**From:** Louise Cristobal  
**Sent:** 29 March 2022 15:44  
**To:** JohnP Holmes  
**Cc:** Tim Ward  
**Subject:** Re: 2021/94515 22-24, New Street, Huddersfield, HD1 2BU 3 Sculptural features

**From:** JohnP Holmes <JohnP.Holmes@kirklees.gov.uk>  
**Sent:** 29 March 2022 11:28  
**To:** Louise Cristobal <Louise.Cristobal@kirklees.gov.uk>  
**Subject:** 2021/94515 22-24, New Street, Huddersfield, HD1 2BU 3 Sculptural features

Vertical Planters Location - New Street, Huddersfield

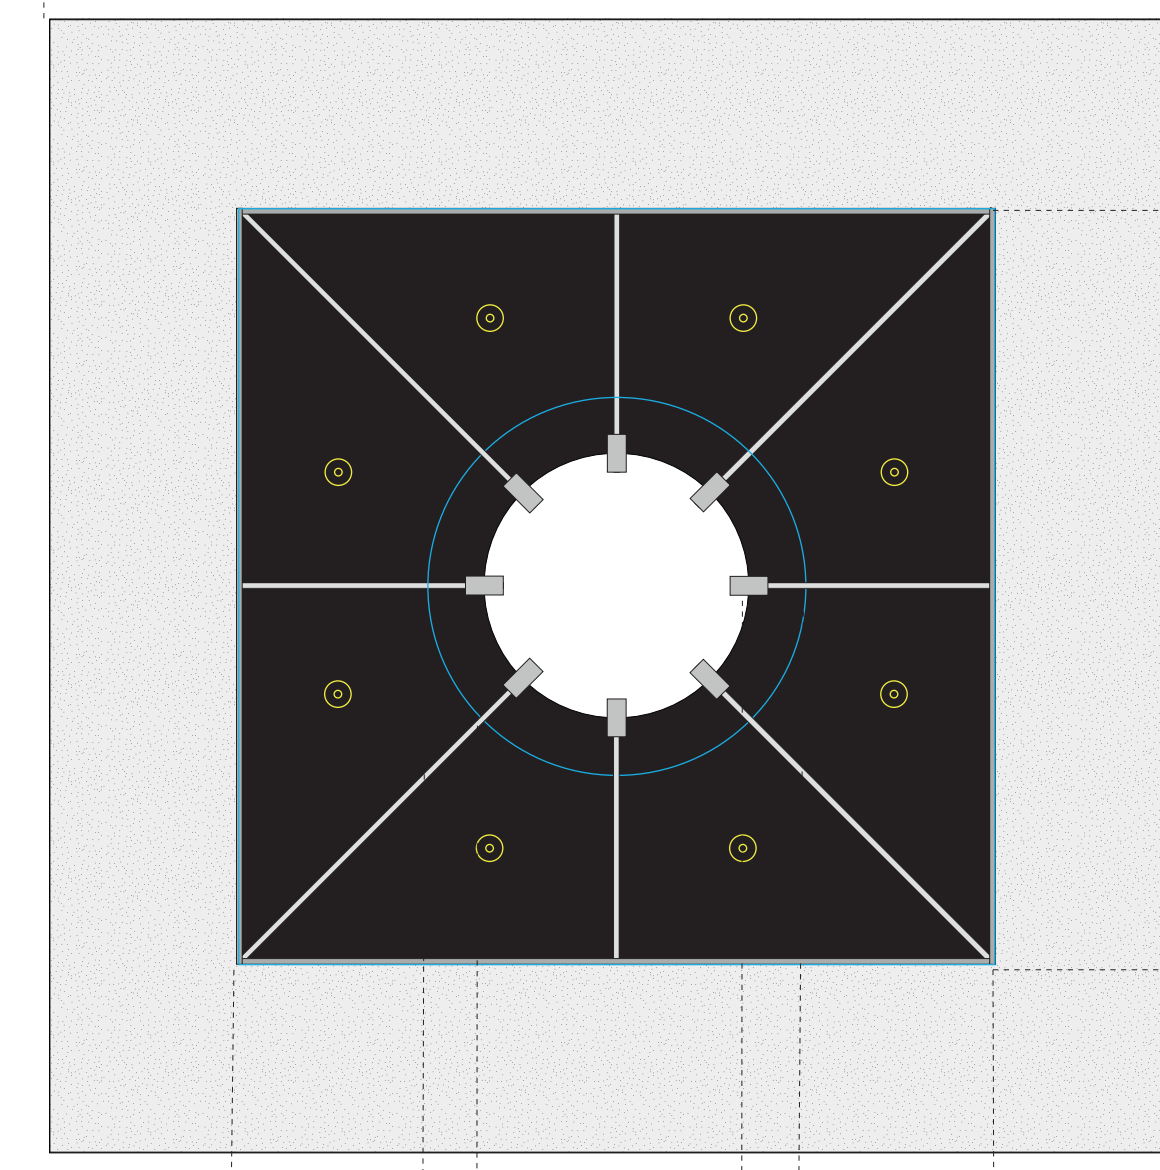
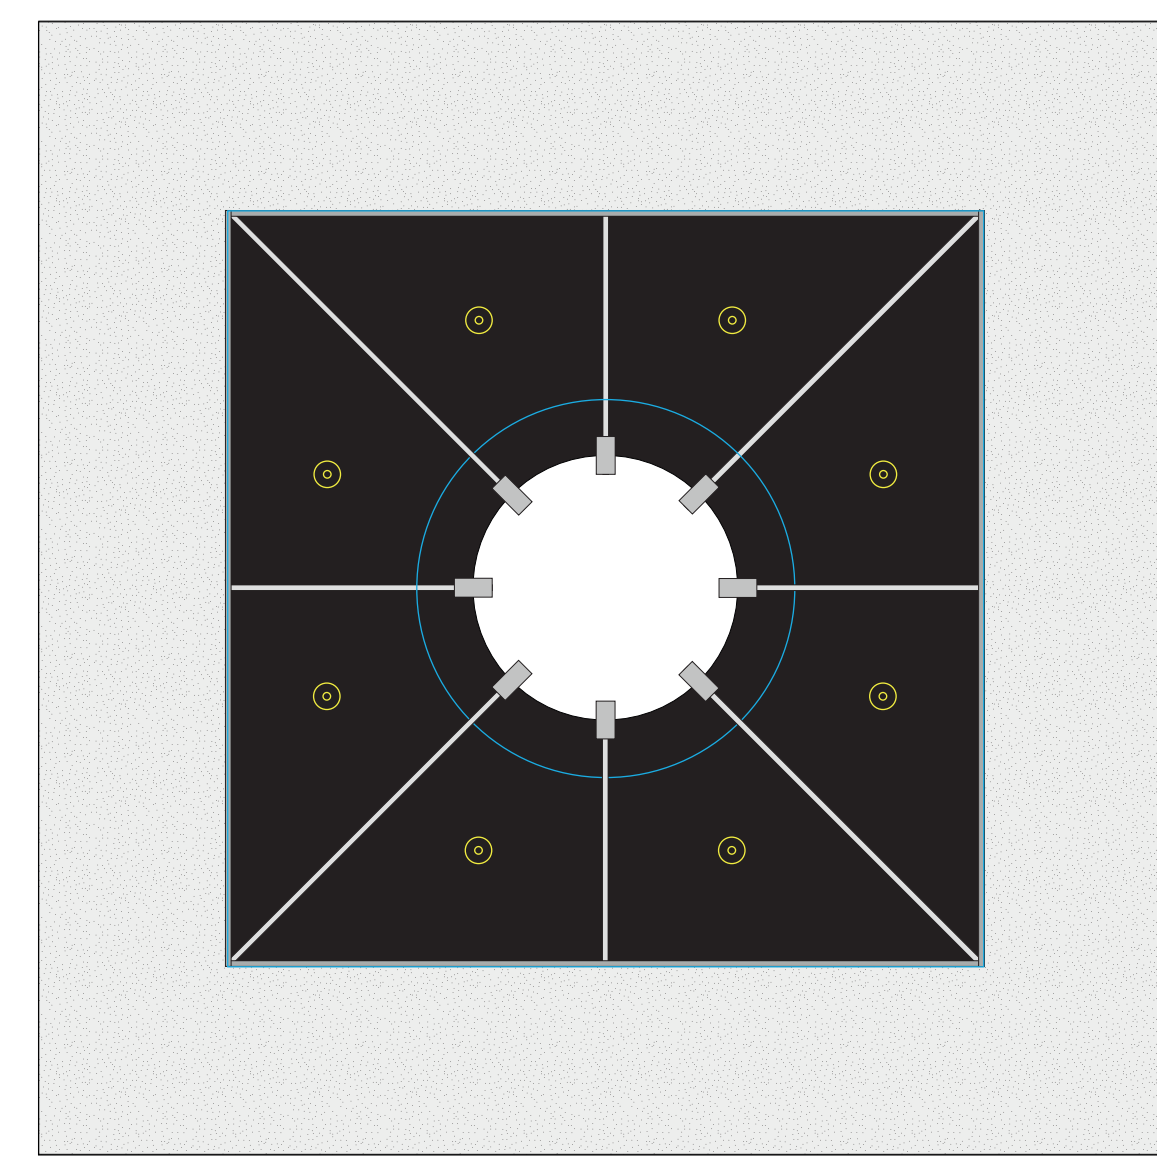
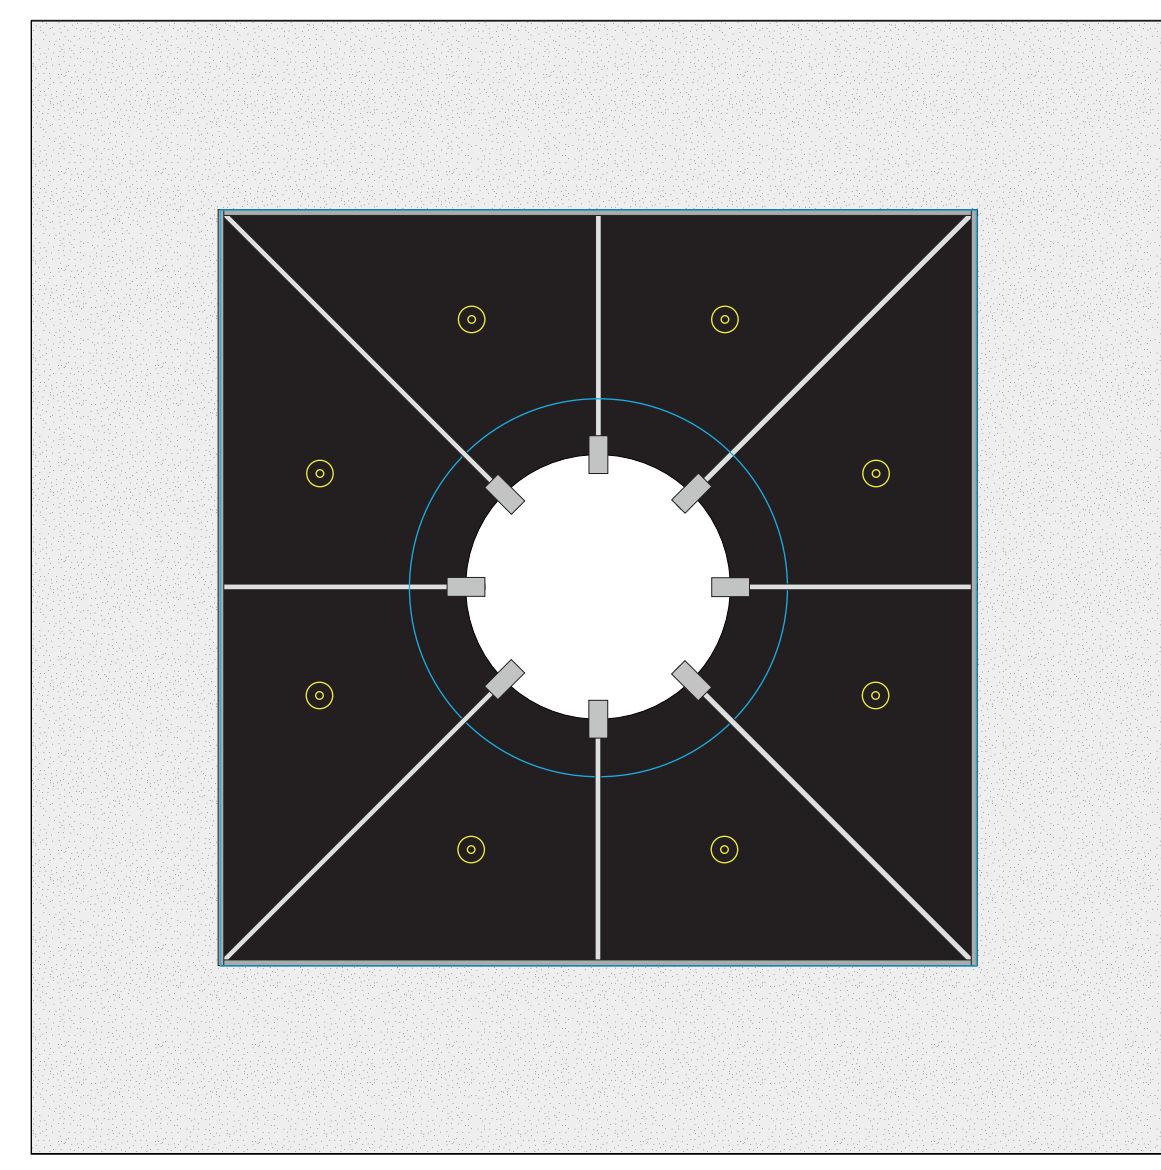
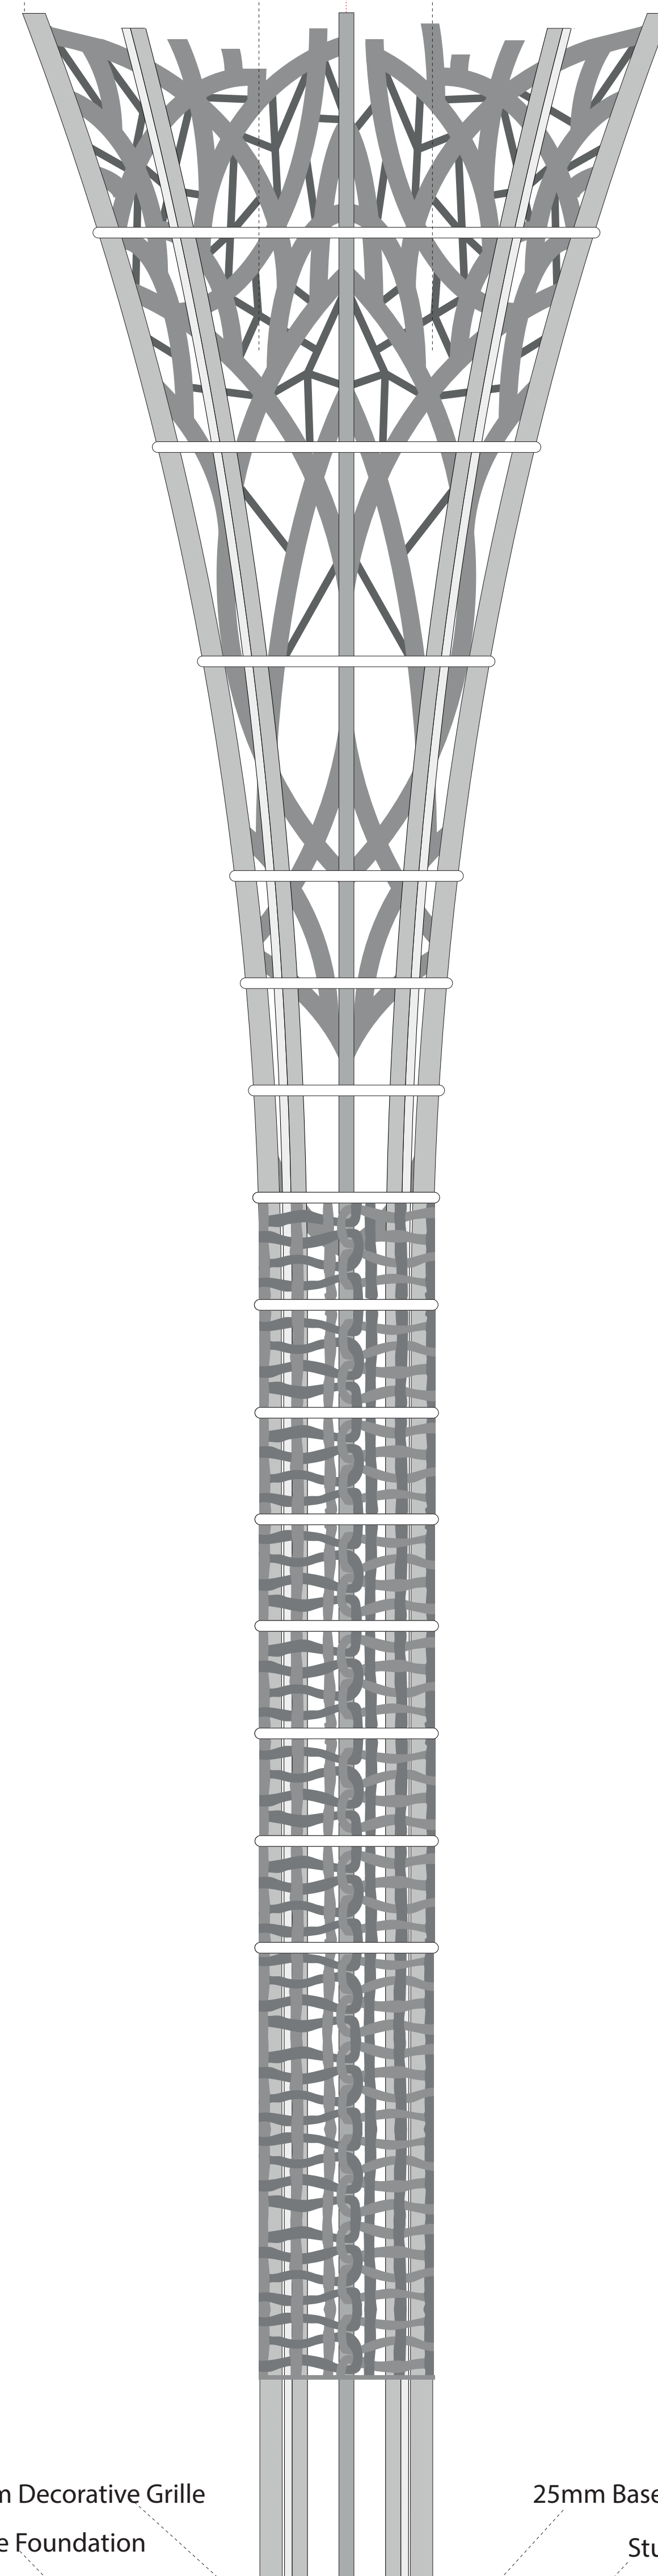
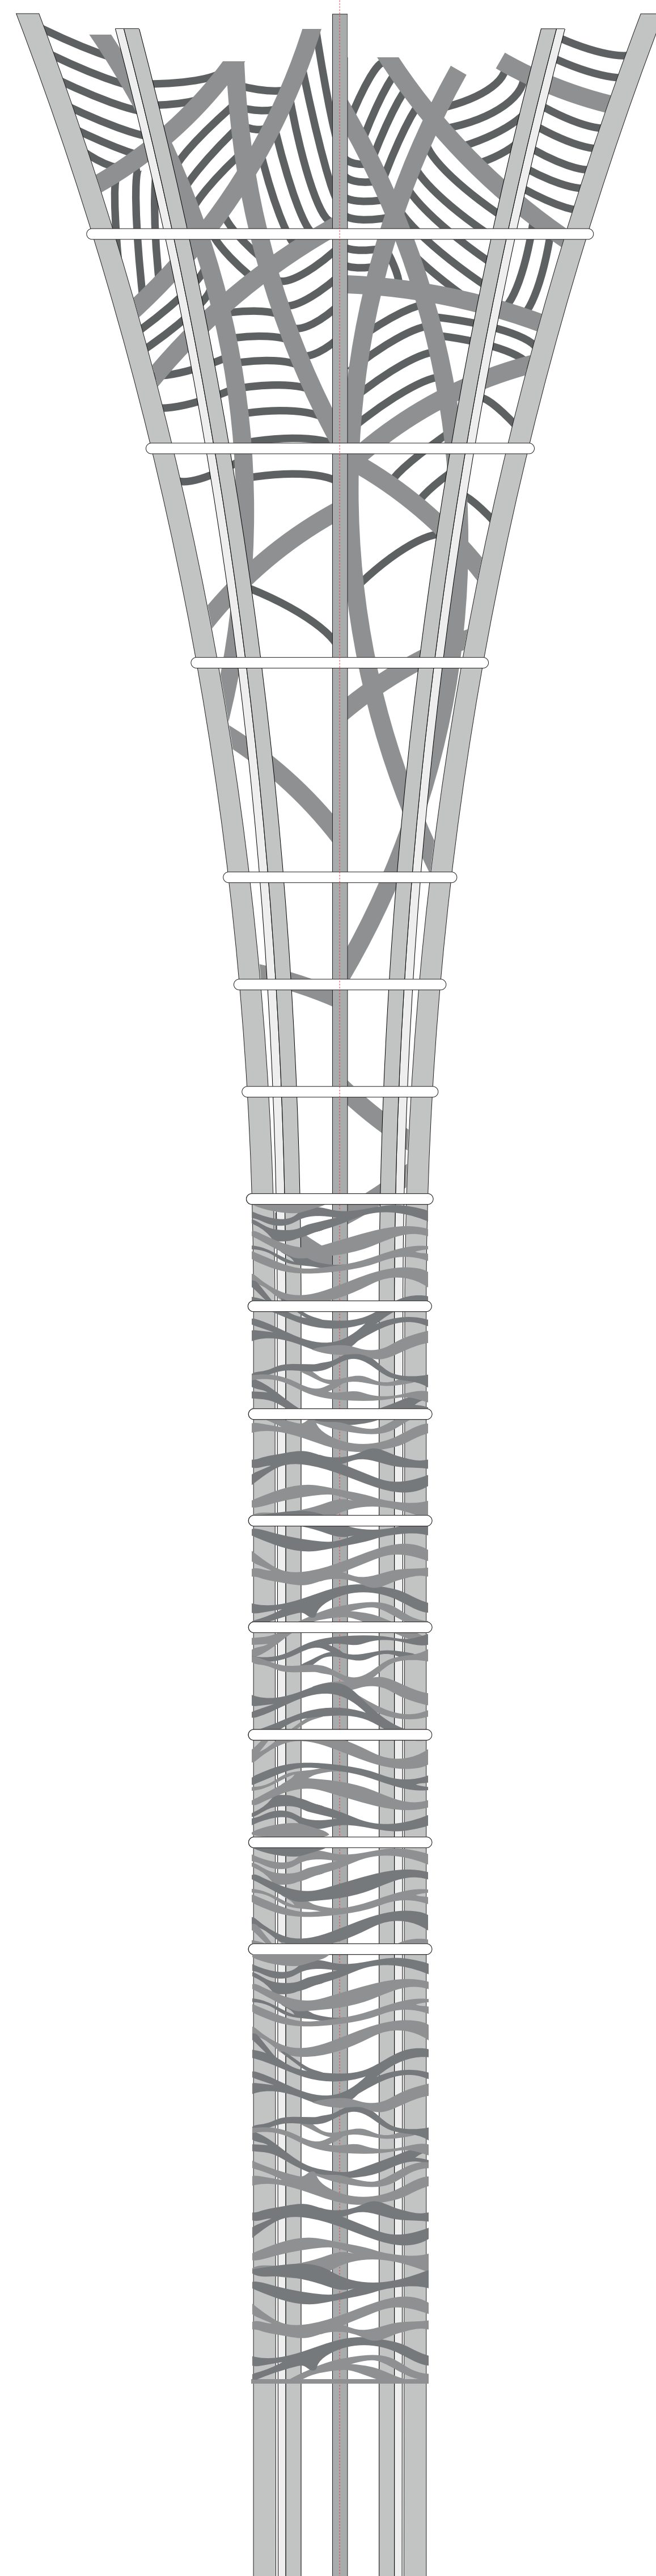
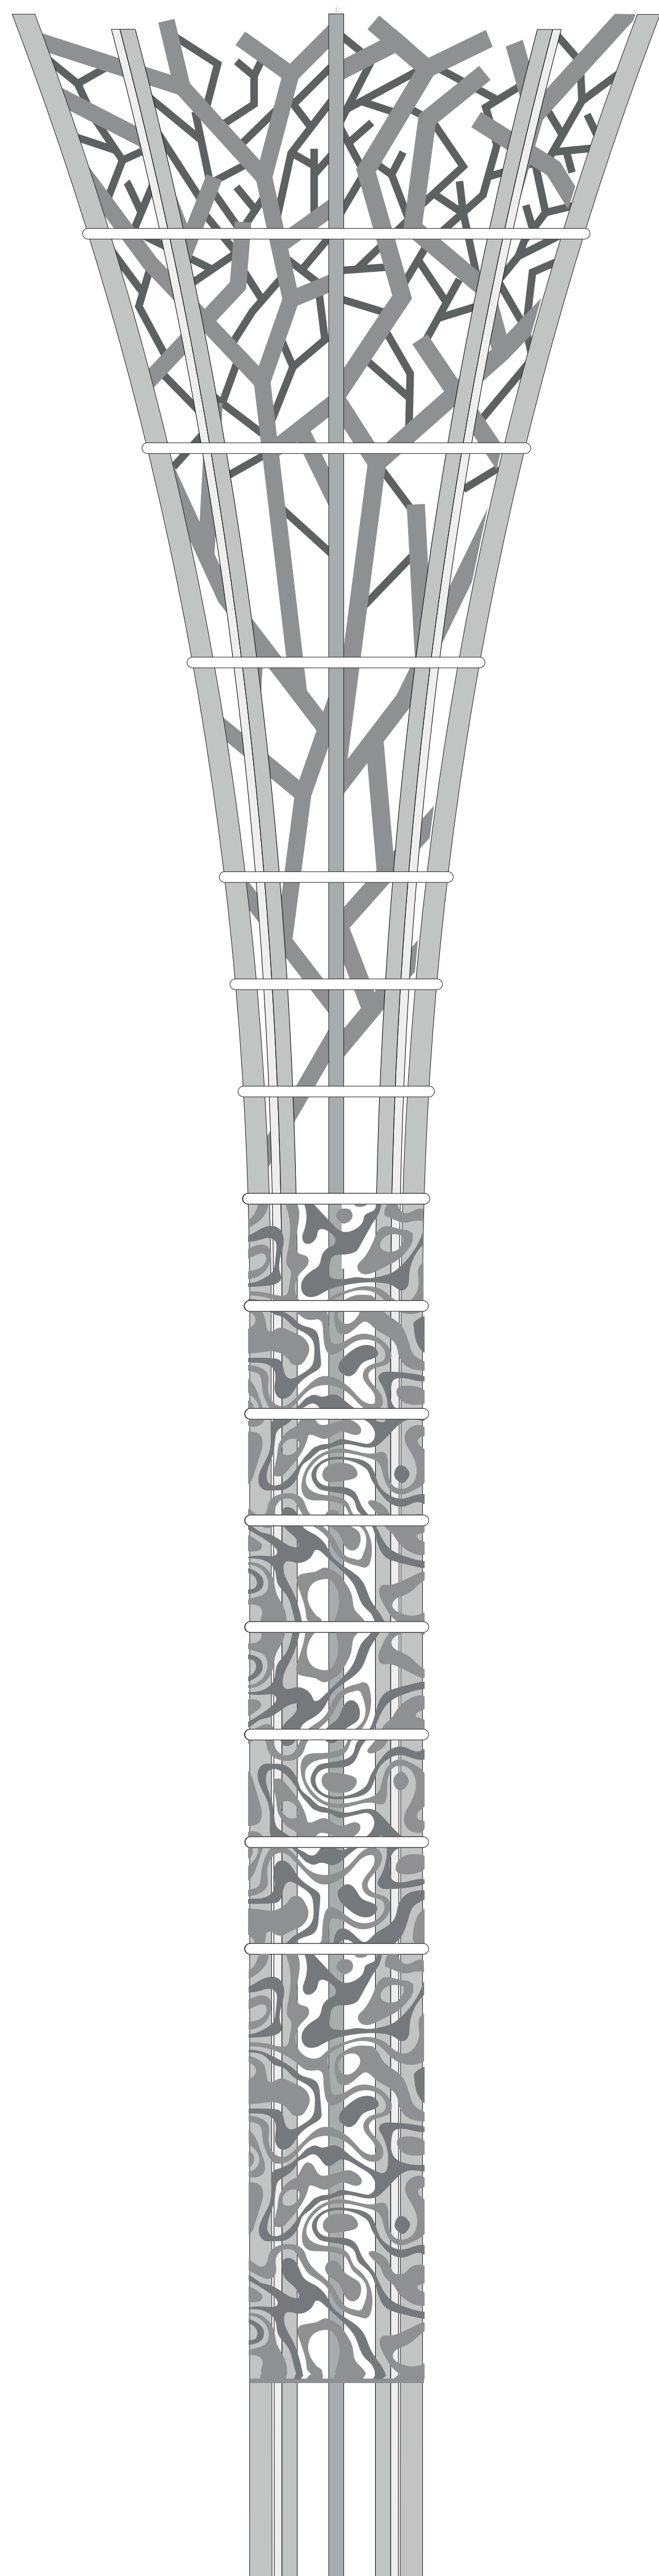
Another question I have is that whilst the plans show the sculptures will be powder coated finish I am not sure what the specific colour will be. Is it intended to be grey as per the plans? Do you know the specific colour they will be (a RAL colour code would be useful if it is known).

The RAL colour will be 9016 (Traffic white)  
I look forward to the decision this week.
